Application for a non-material amendment following a grant of planning permission.

Planning Application - Conversion of barn to form 1 no. dwelling and erection of glasshouse and store

Amendment to cladding and minor fenestration changes to scheme approved under DC/20/3633 and DC/20/3634

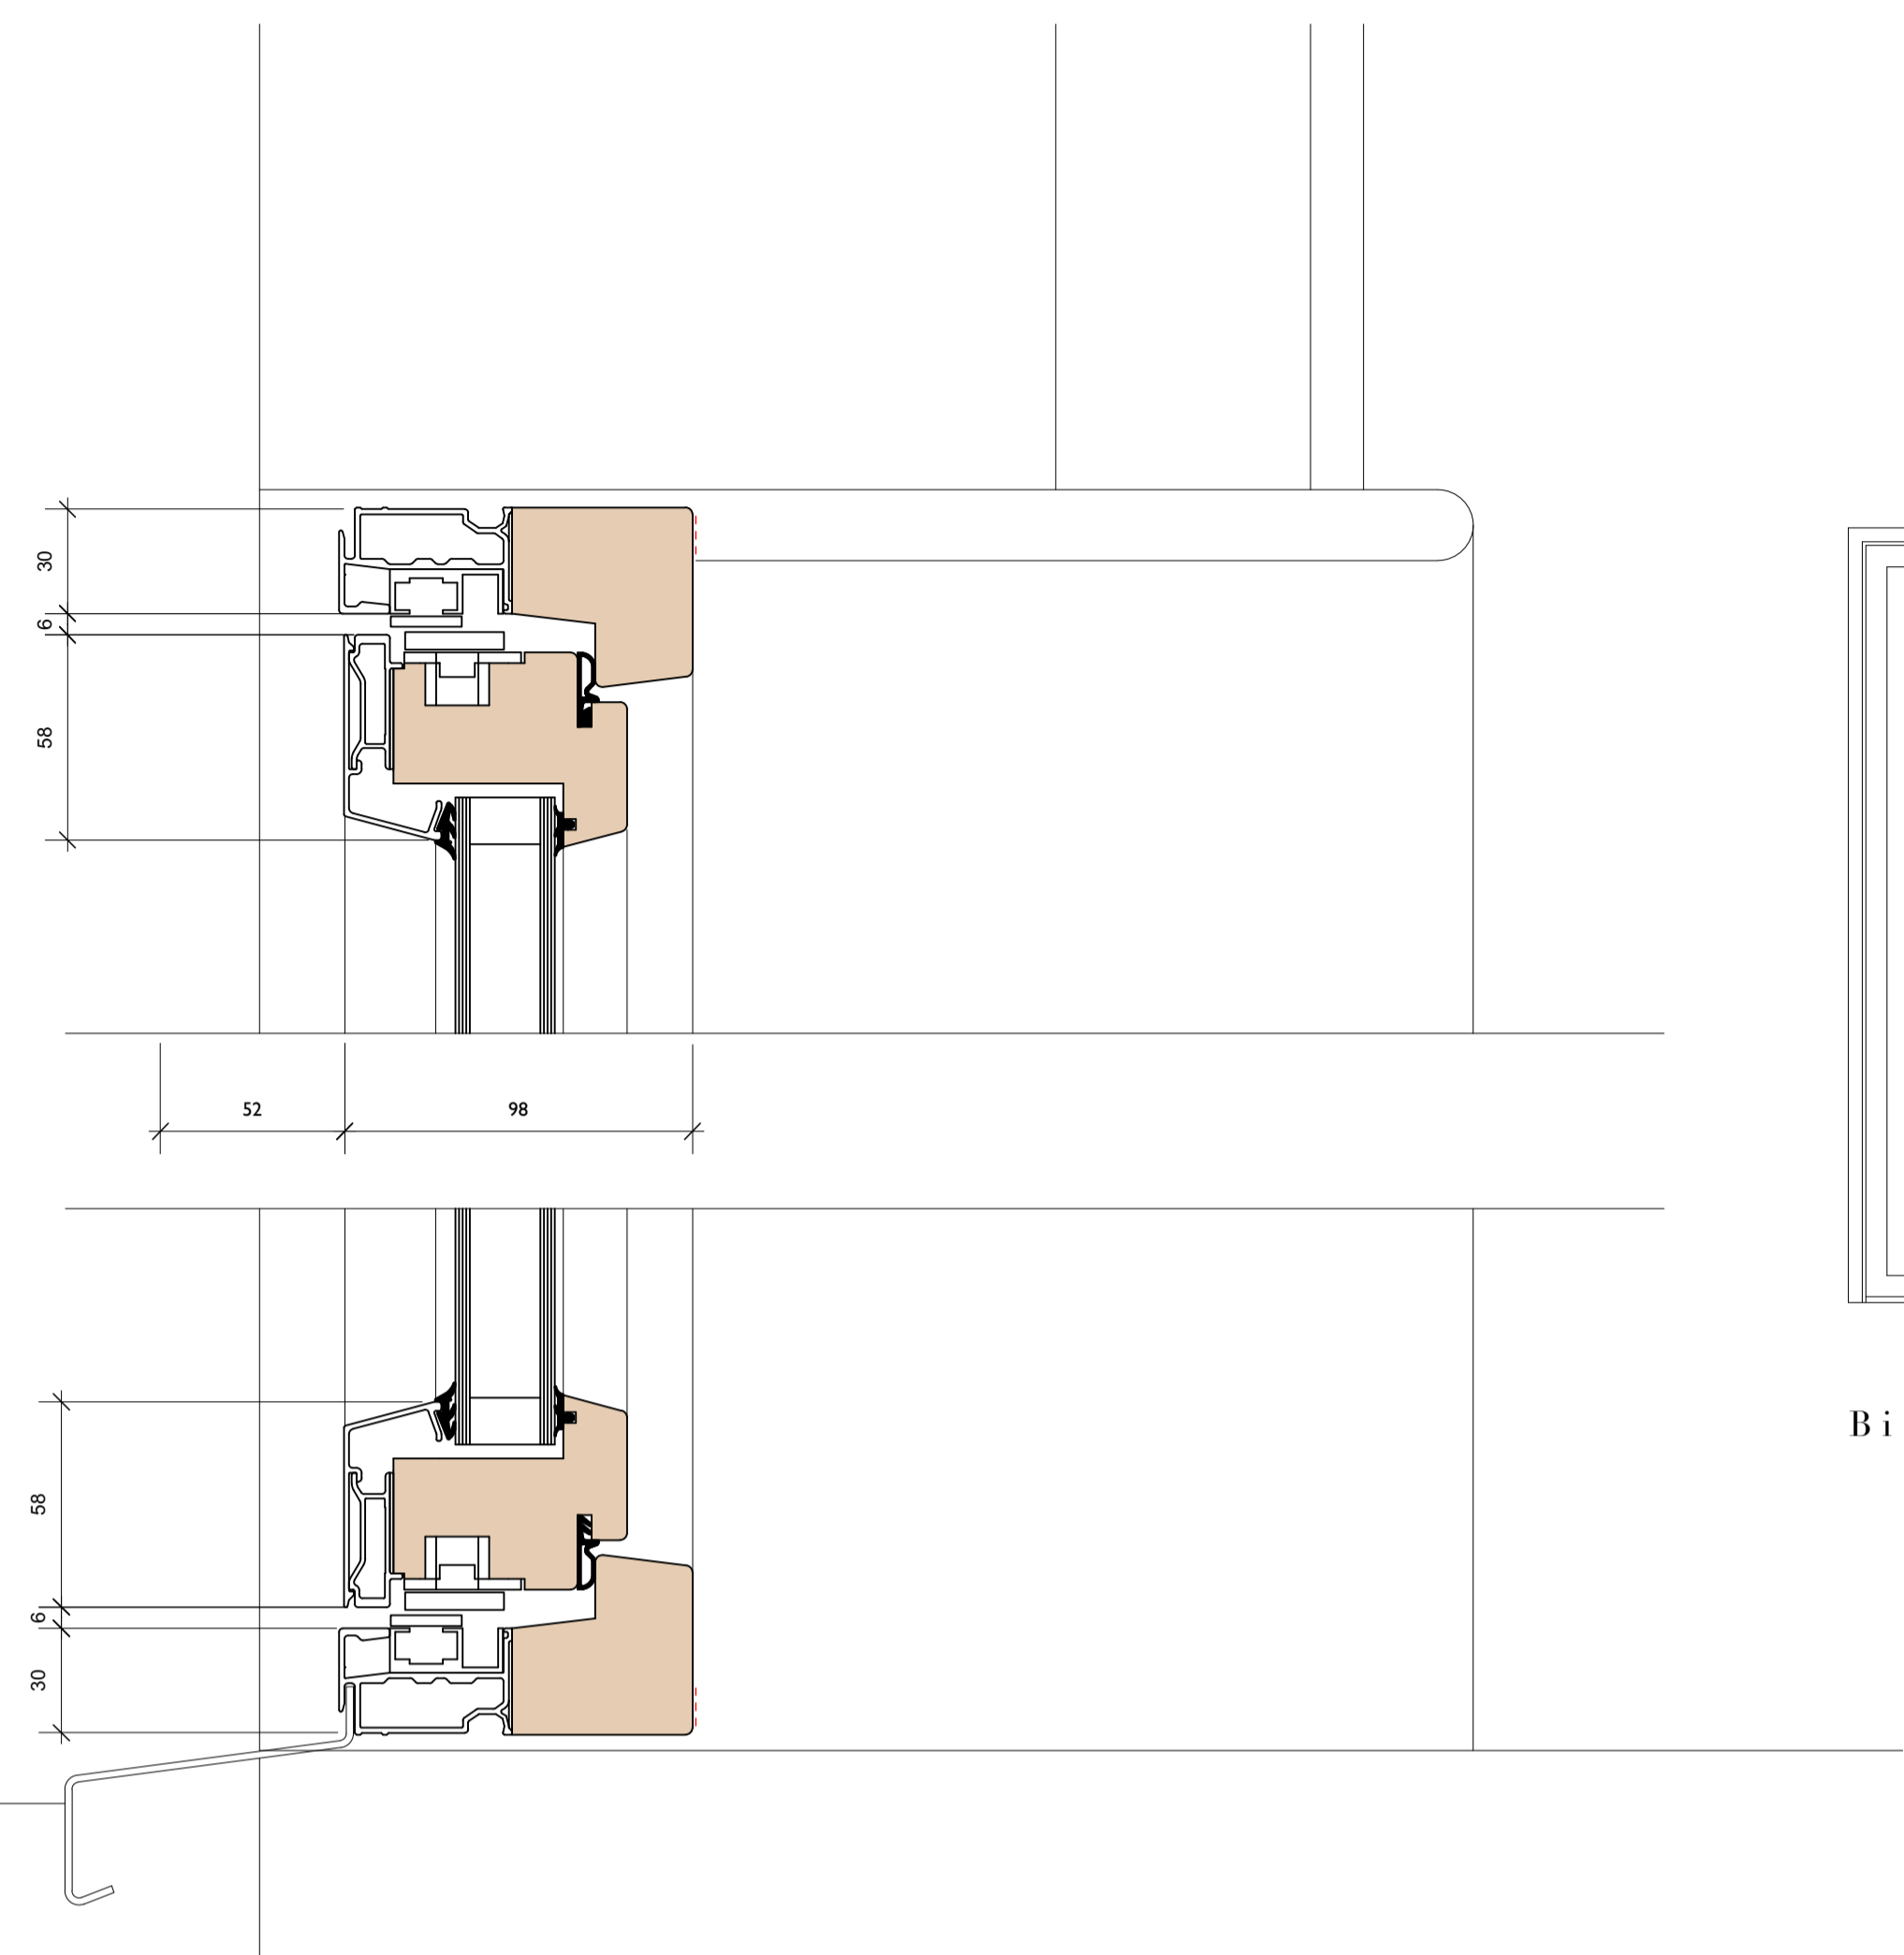
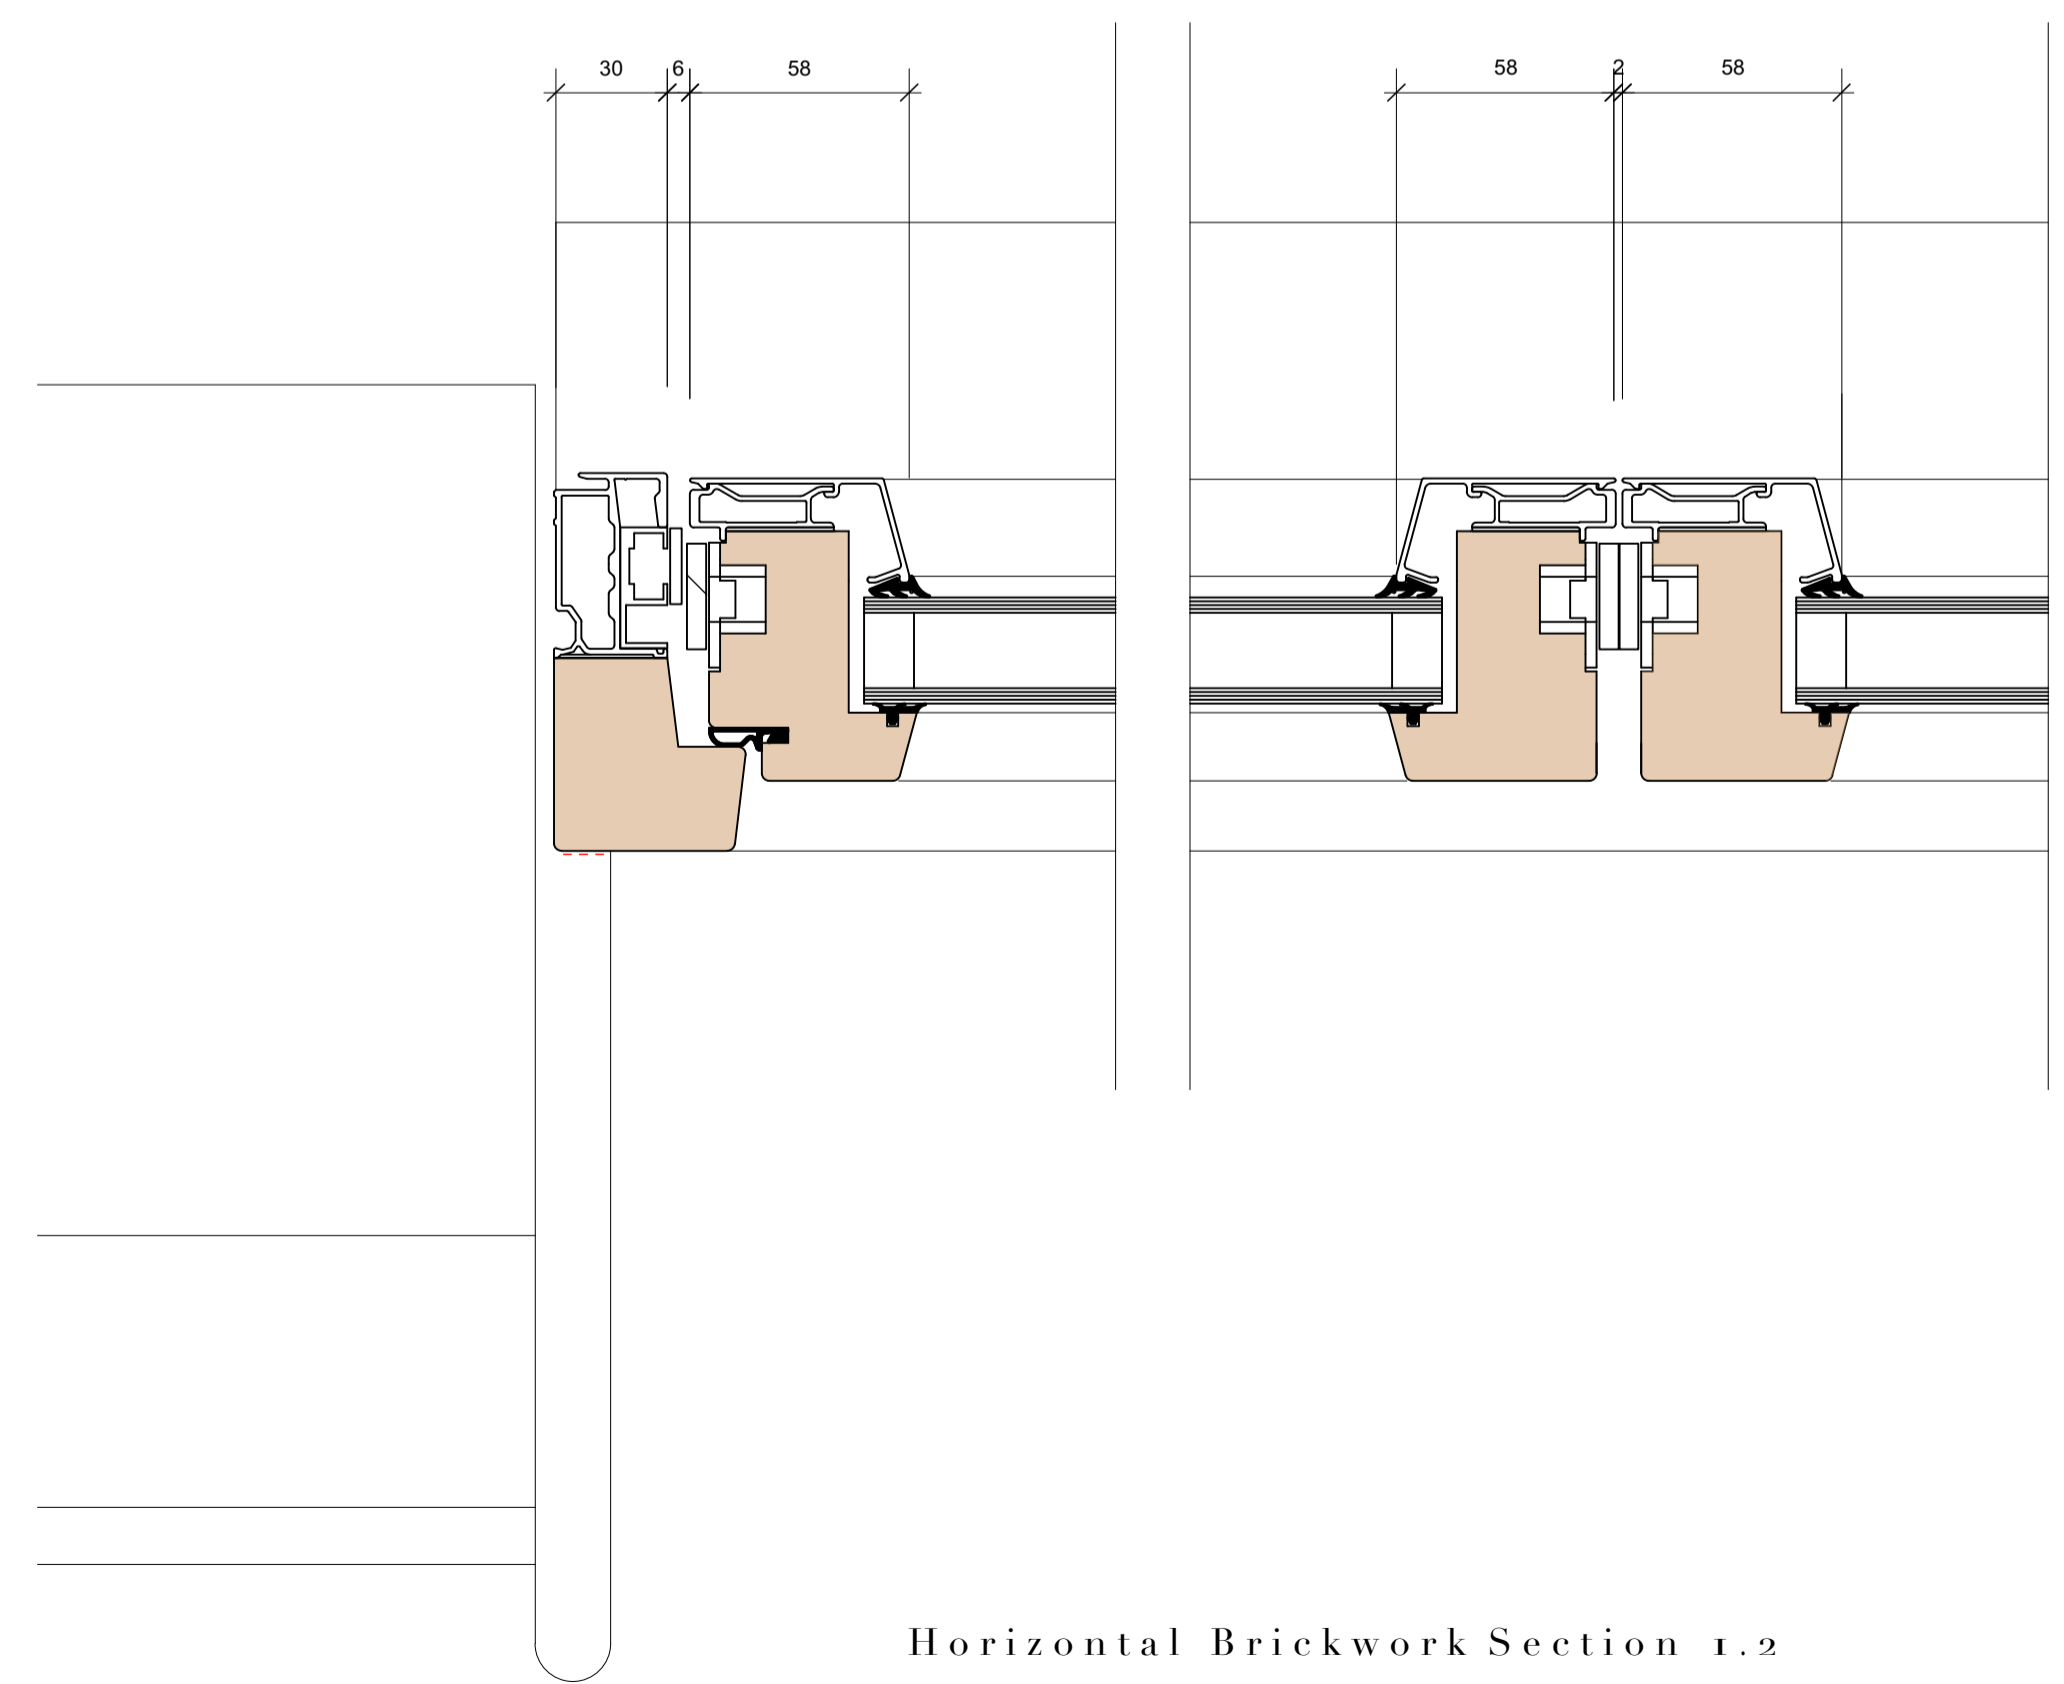
TO1 - 11 - Elevations 1
TO1 - 12 - Elevations 2
TO1 - 08 - Joinery

TO1 - 11 A - Elevations 1
TO1 - 12 A - Elevations 2
TO1 - 08 A - Joinery
